ENG-SF20028-R1-CDS.pdf Markup Summary

EPC STORMWATER REVIEW COMMENT
IN ORANGE BOXES WITH BLACK TEXT

PCD Filing No.:
SF-20-028

**FOUNTAIN GRASS GROVE_EAST PROFILE
STA 1+00.00 TO 4+85.65**

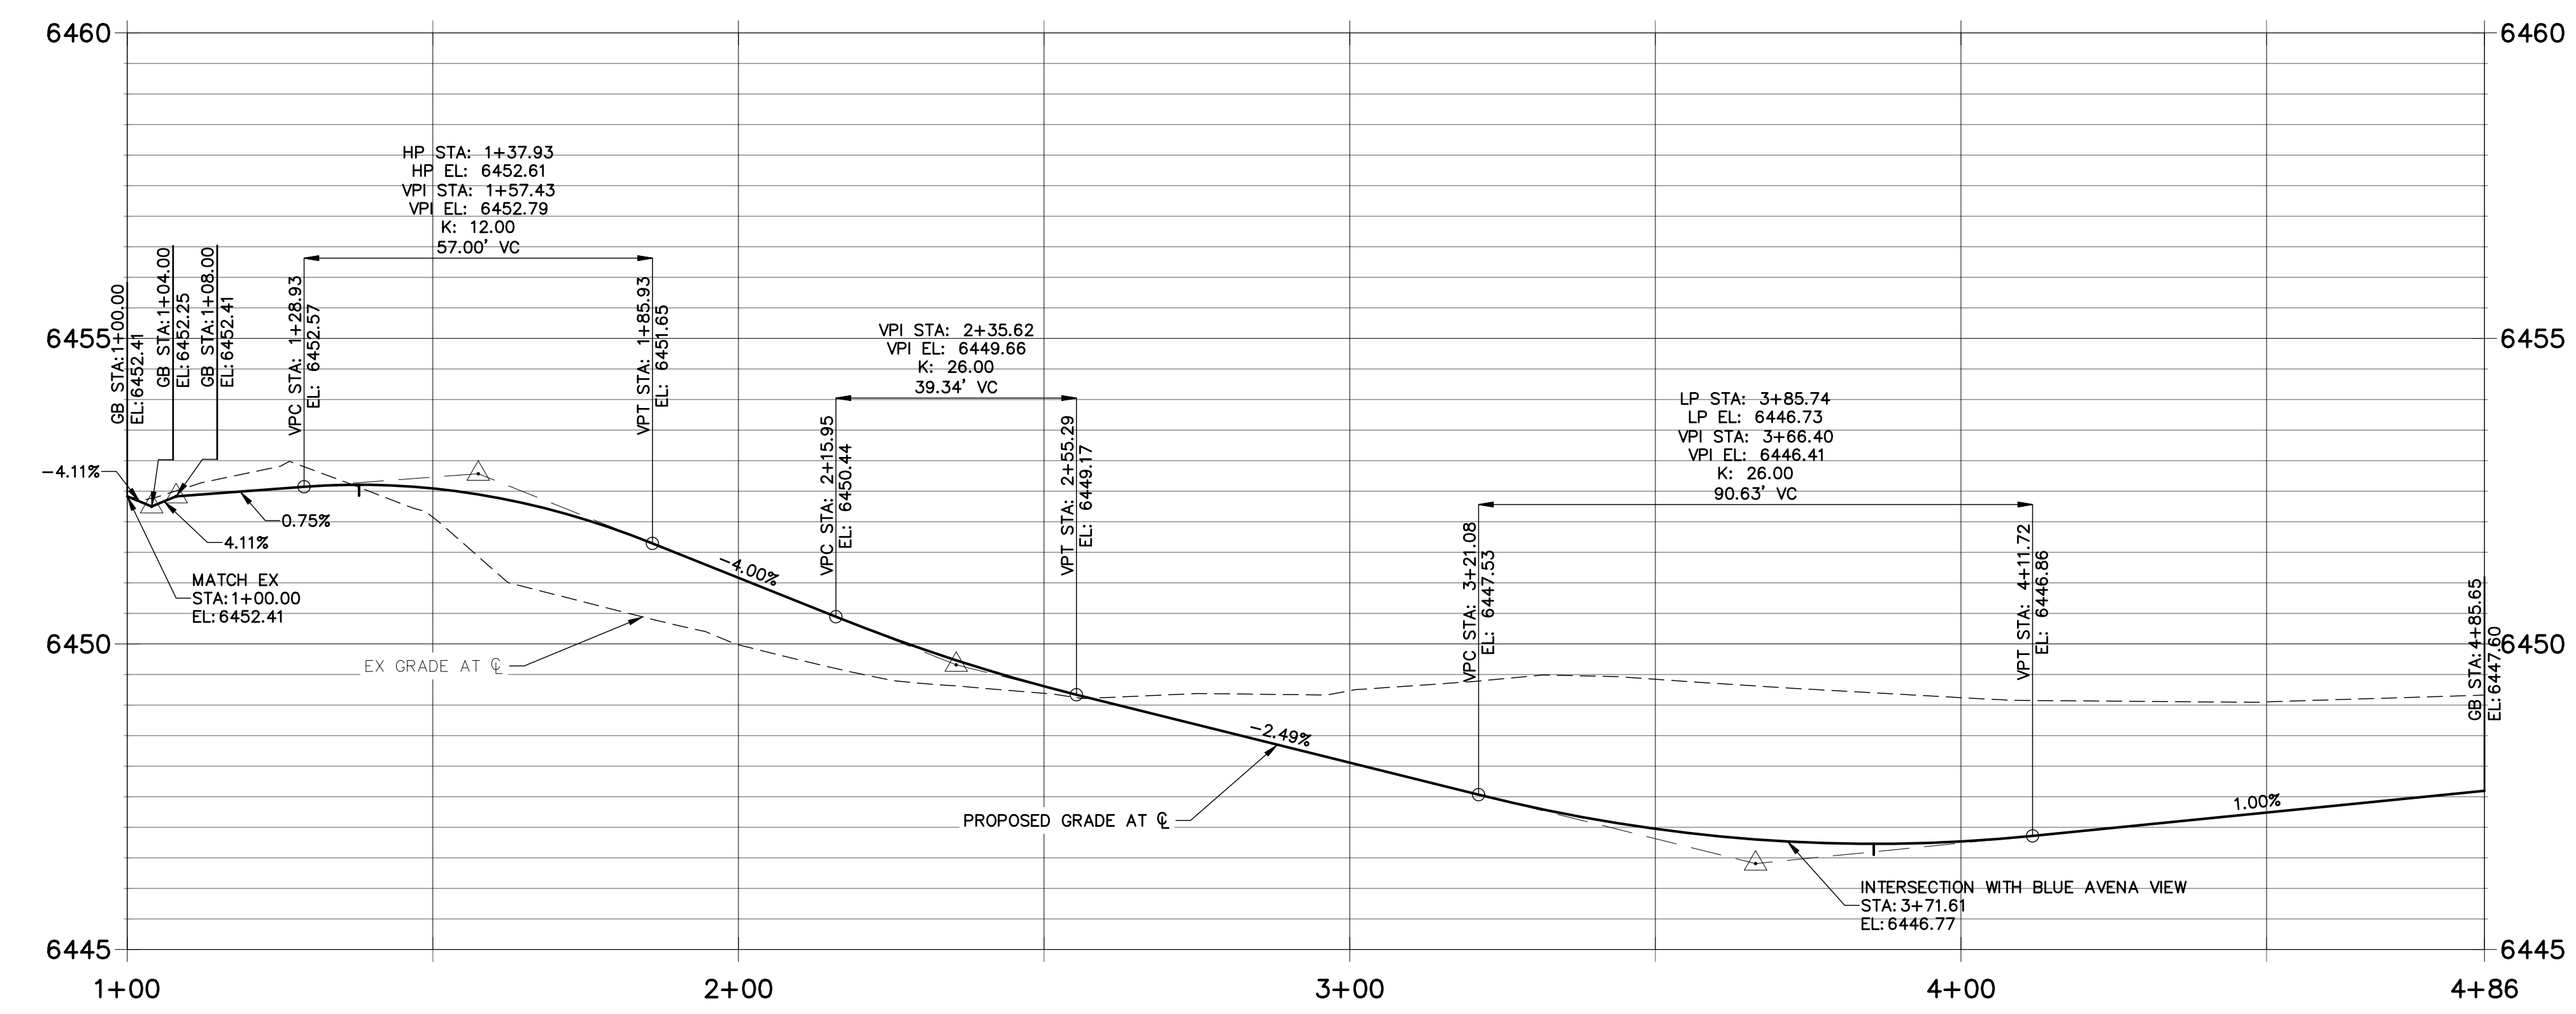
Where does sidewalk end?

Sidewalk should be bumped out to ROW. A deviation will be required to have a private sidewalk outside of ROW in a public access easement.

Is this a retaining wall? If so it needs to be off of ROW line.

URBAN COLLECTION AT PALMER VILLAGE
STORM PLANS

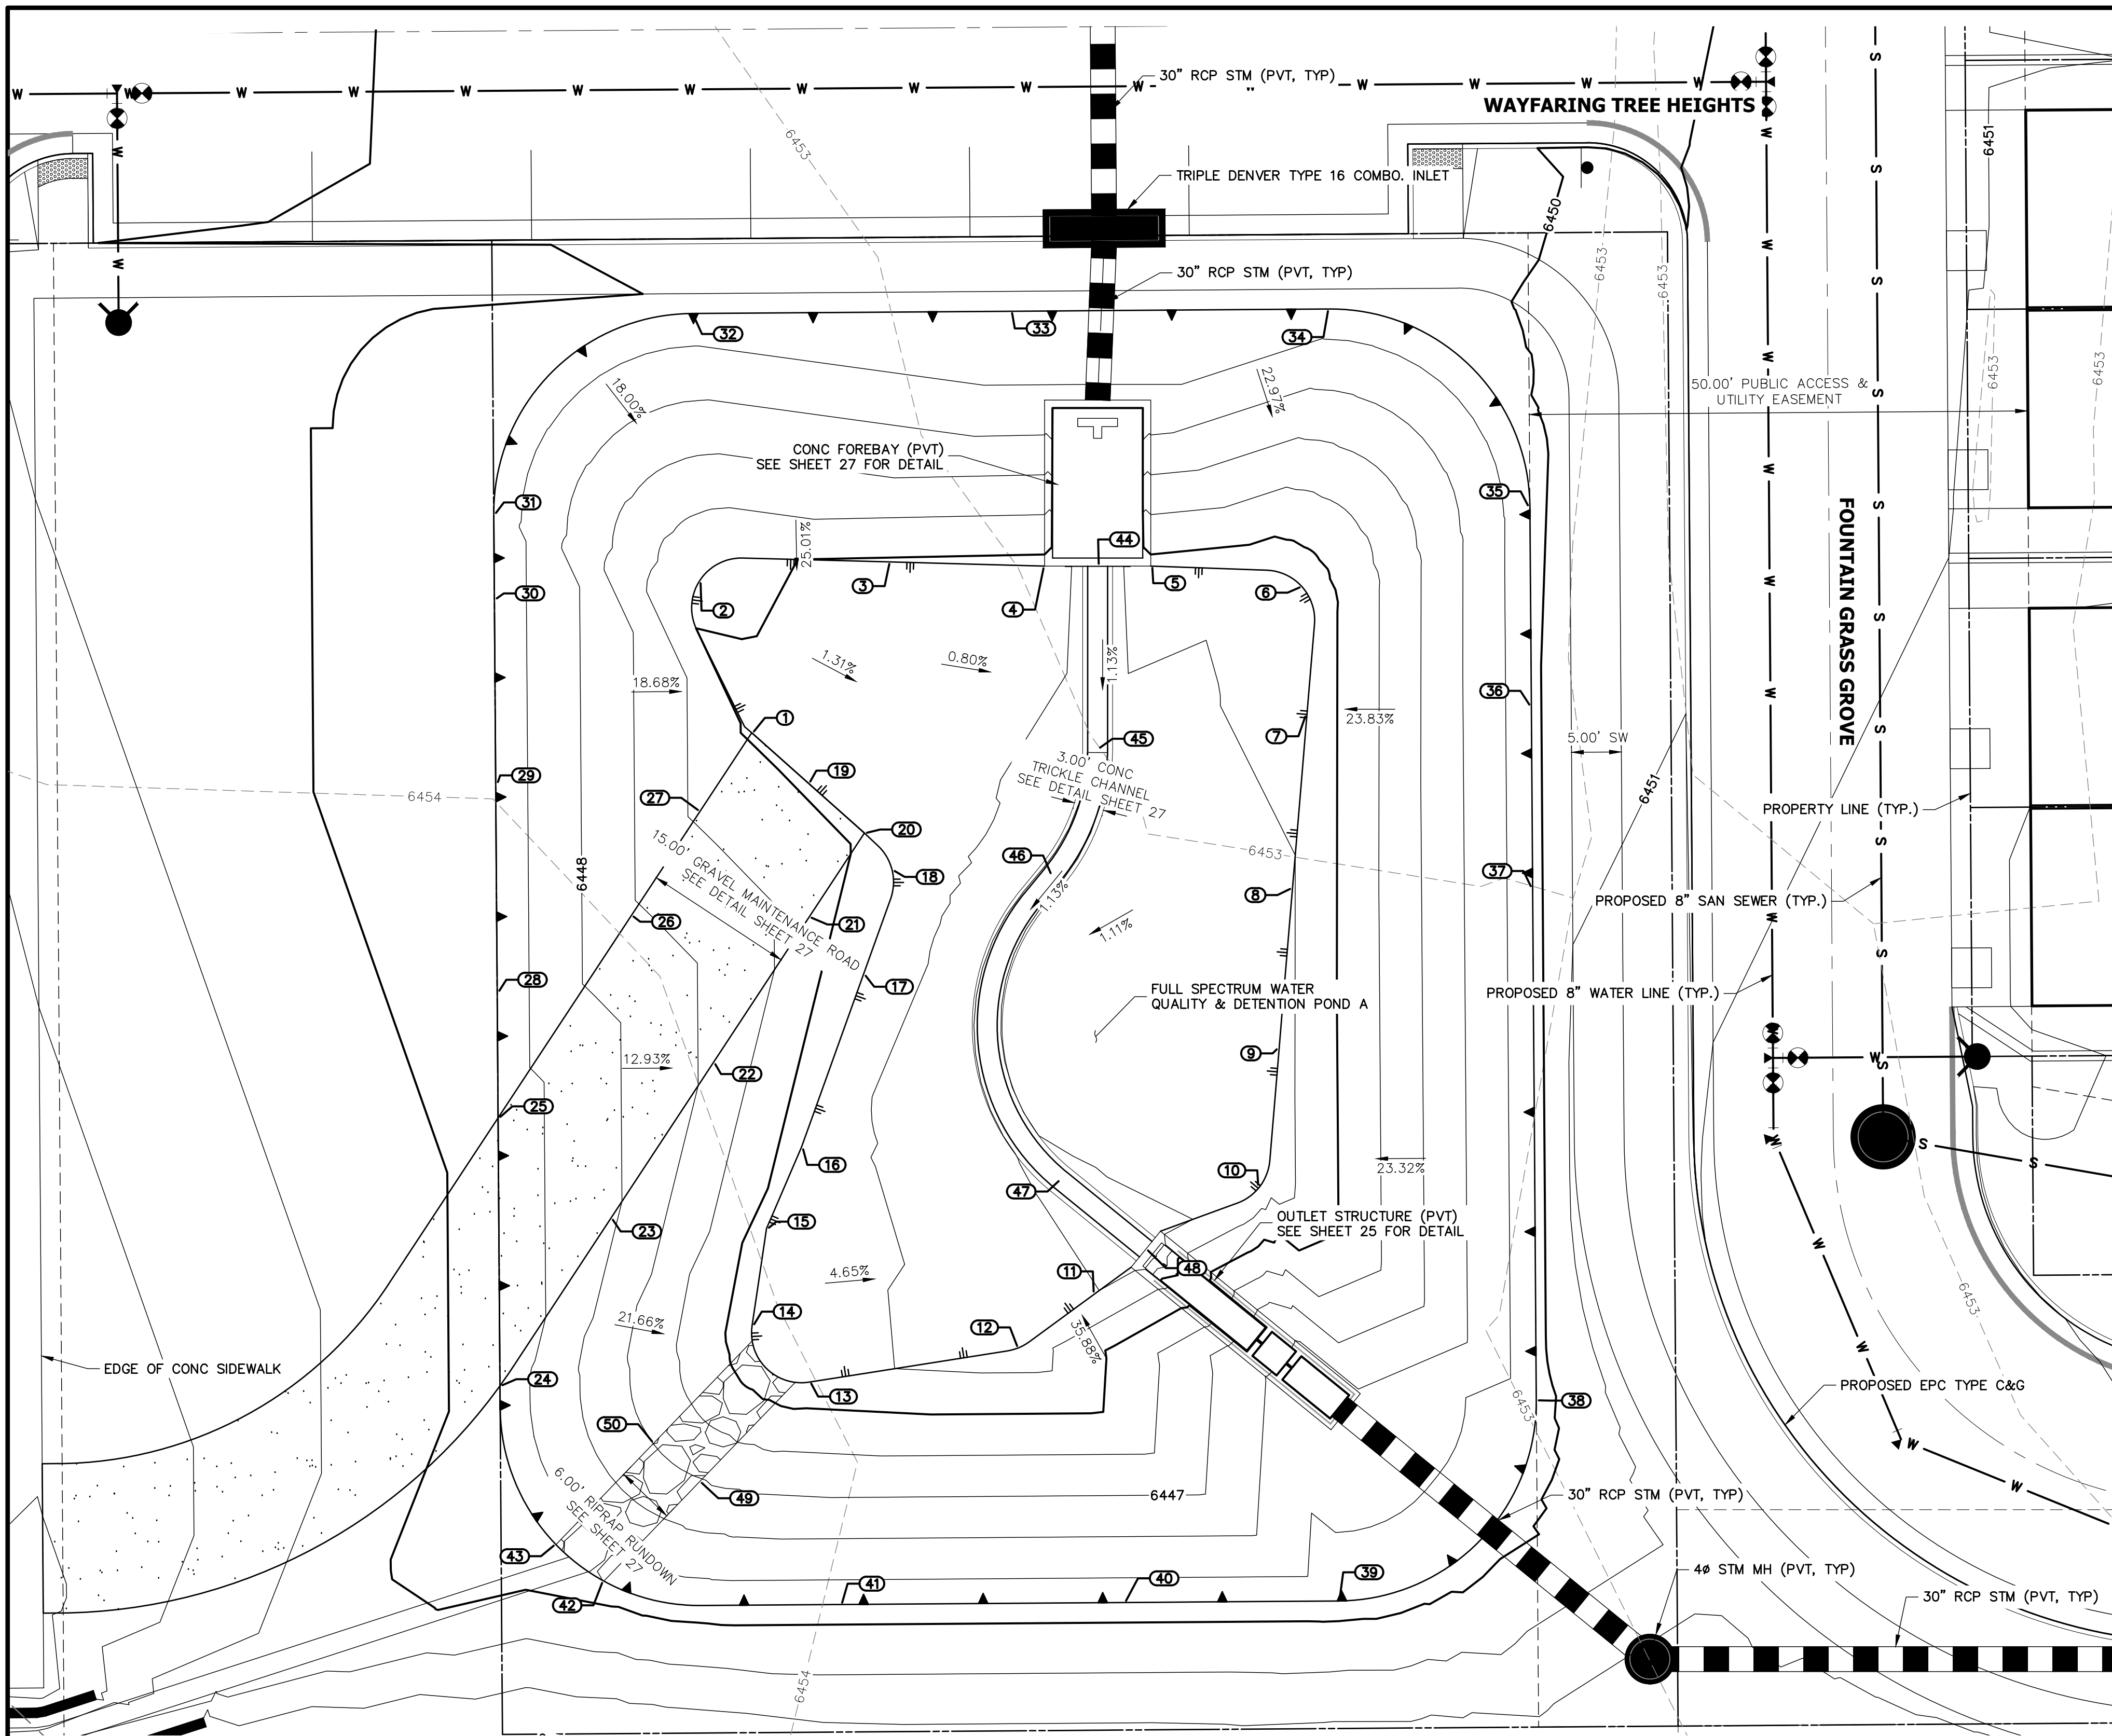
Show the whole access road/path

Access ramp shall be a minimum of 15 ft wide at a slope no greater than 12%, in accordance with DCM Vol. 1 Section 11.2.2
